FP/107/21/HH

PLANNING APPLICATION FOR PROPOSED  
PORCH DEVELOPMENT AT  
N°4 DERWENT GROVE, FELPHAM,  
BOGNOR REGIS, PO22 8NE

GROUND FLOOR PLAN

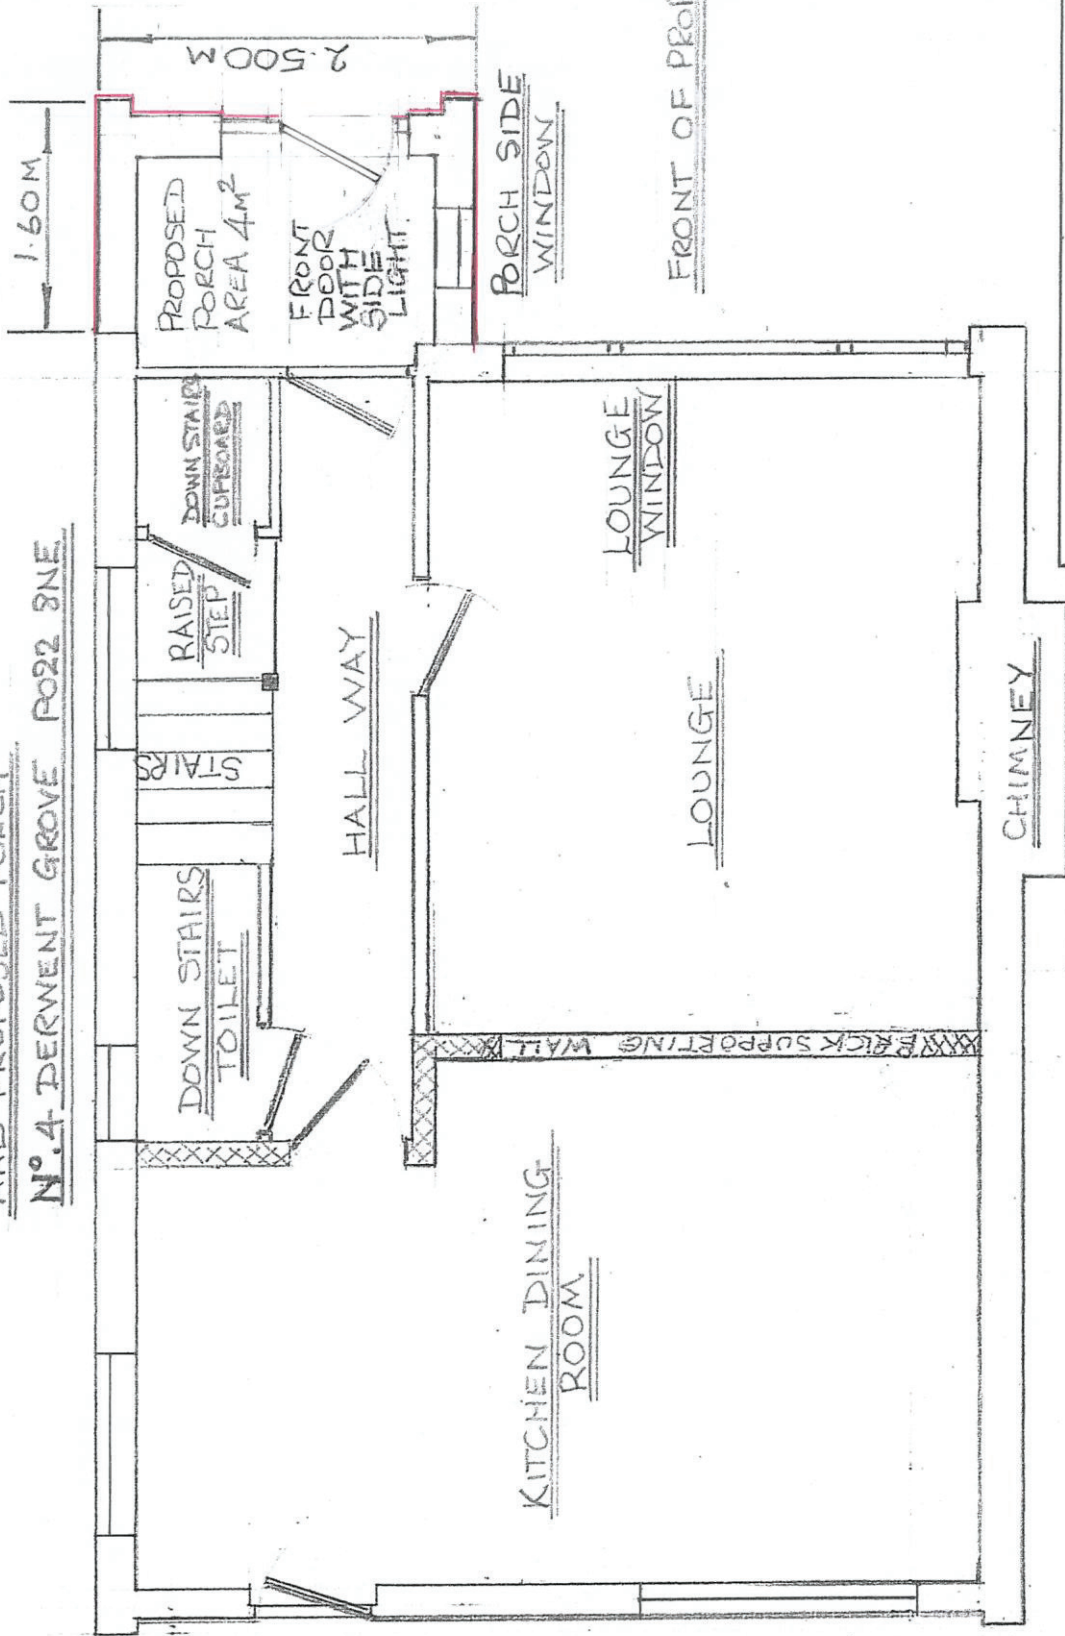
- ① On the existing ground floor and ground floor & porch plans I have added all ground floor windows
- ② On the three elevations plan showing proposed porch development I have moved the front door and side light over to be more in line with the existing front door
- ③ On the ground floor & porch plan I have stepped the front brickwork in giving a brick length width column at both front corners of the porch
